**From:** Laura Gibbons <Laura.Gibbons@arun.gov.uk>  
**Sent:** 26 October 2021 09:29  
**To:** Anita Gardner <Anita.Gardner@arun.gov.uk>  
**Cc:** Planning.Responses <Planning.Responses@arun.gov.uk>  
**Subject:** RE: Planning Consultation on: M/130/21/DOC

**Application No:** M/130/21/DOC

**Site Address:** 8 Manor Way Elmer Middleton-On-Sea PO22 6LA

**Description of Works:** Approval of details reserved by condition imposed under ref M/86/20/PL relating to Condition No 3 - surface water drainage.

REAR GARDEN GROUND FLOOR TERRACE
CONSTRUCTION PERMEABLE BLOCK PAVING
(Scale 1:20)

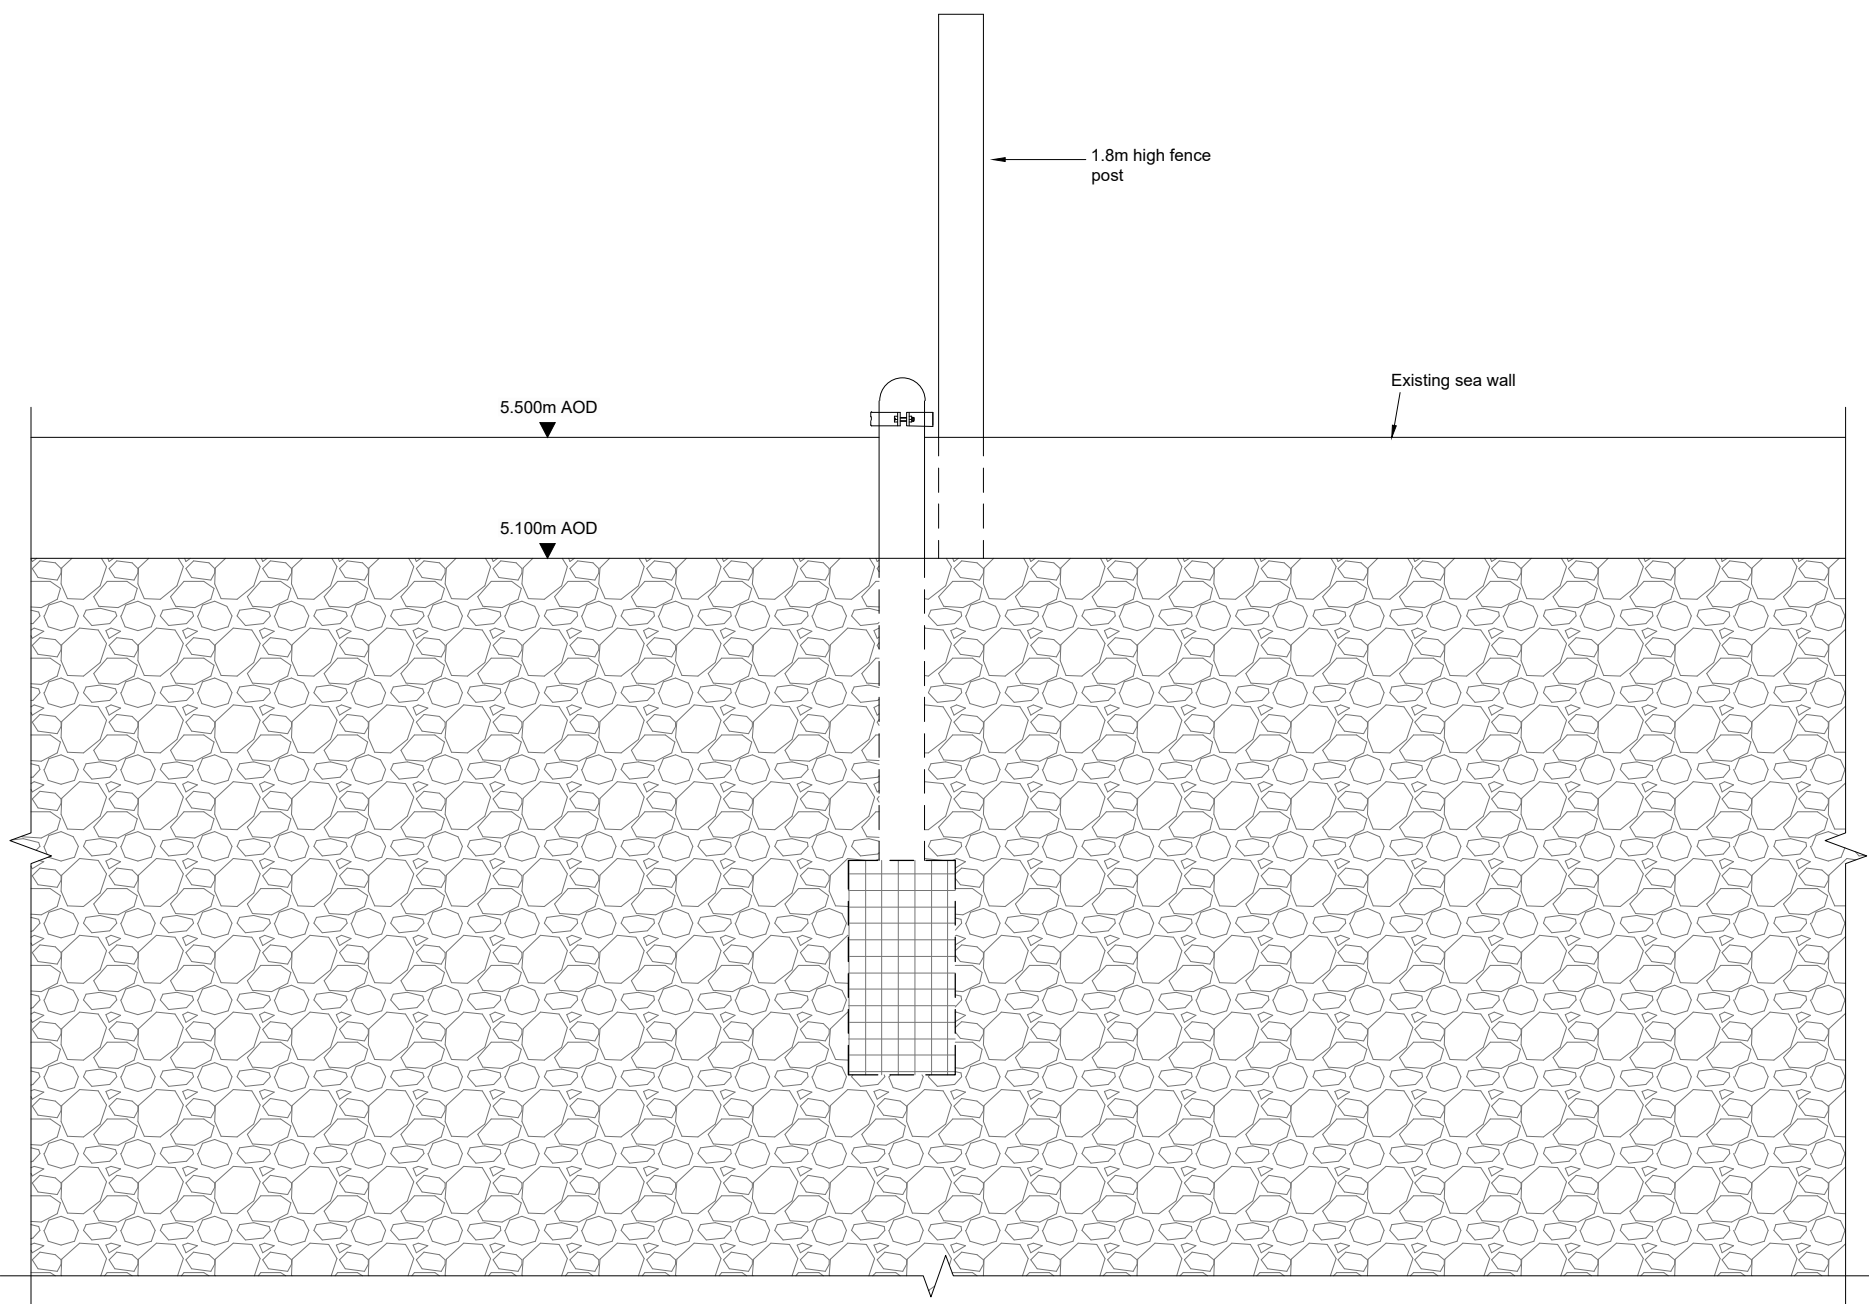
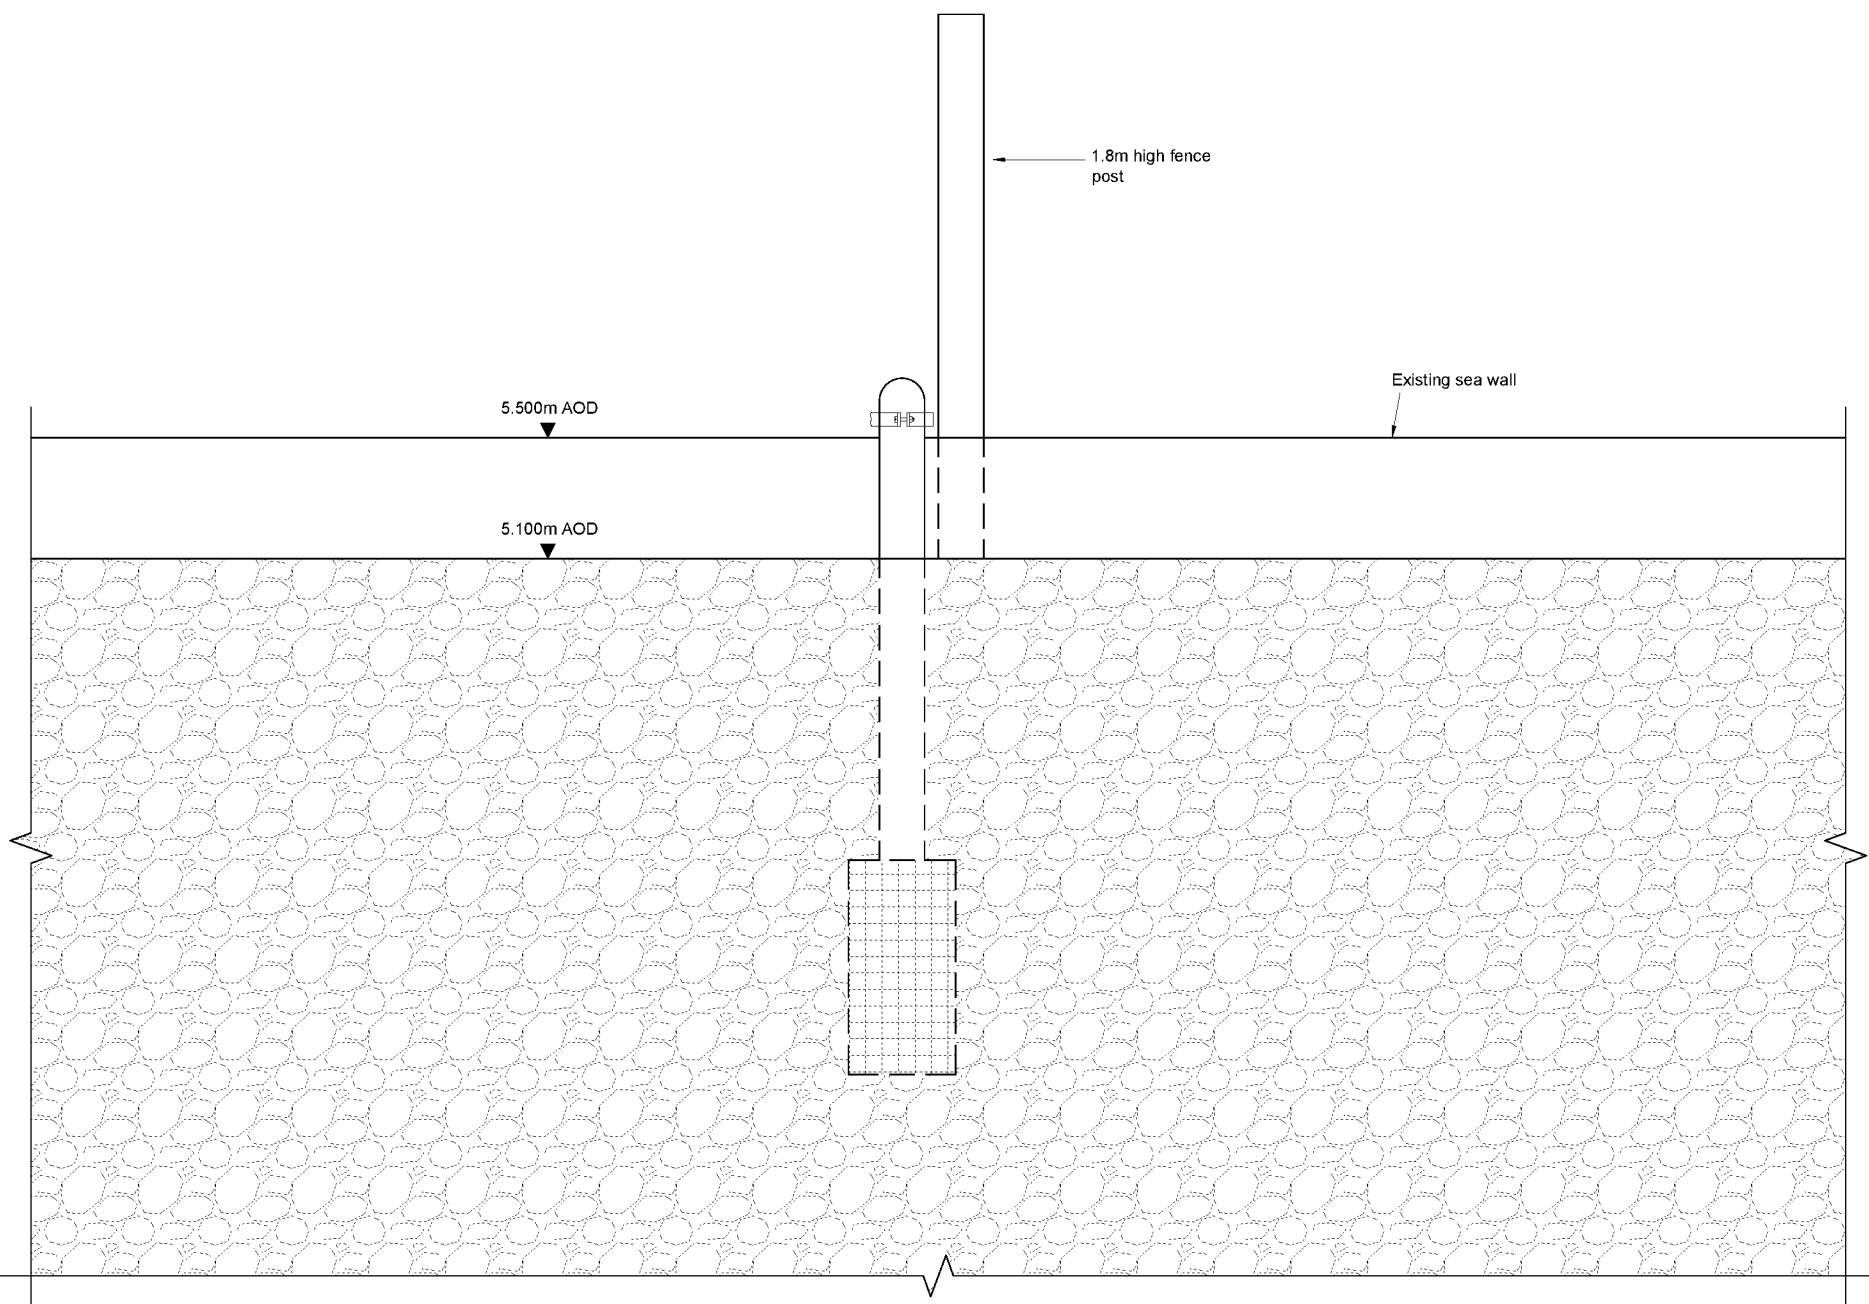
Please can an impermeable liner be provided to the sides of the rear garden ground floor terrace to ensure that water does not travel through the sides of this raised area and infiltrates through the bottom only.

Further to Laura's comment we have added an impermeable membrane to the sides of the rear garden terrace area on drawings 201A and 501A, copies attached. I trust this will allow the surface water scheme and Planning Condition 3 to be discharged.
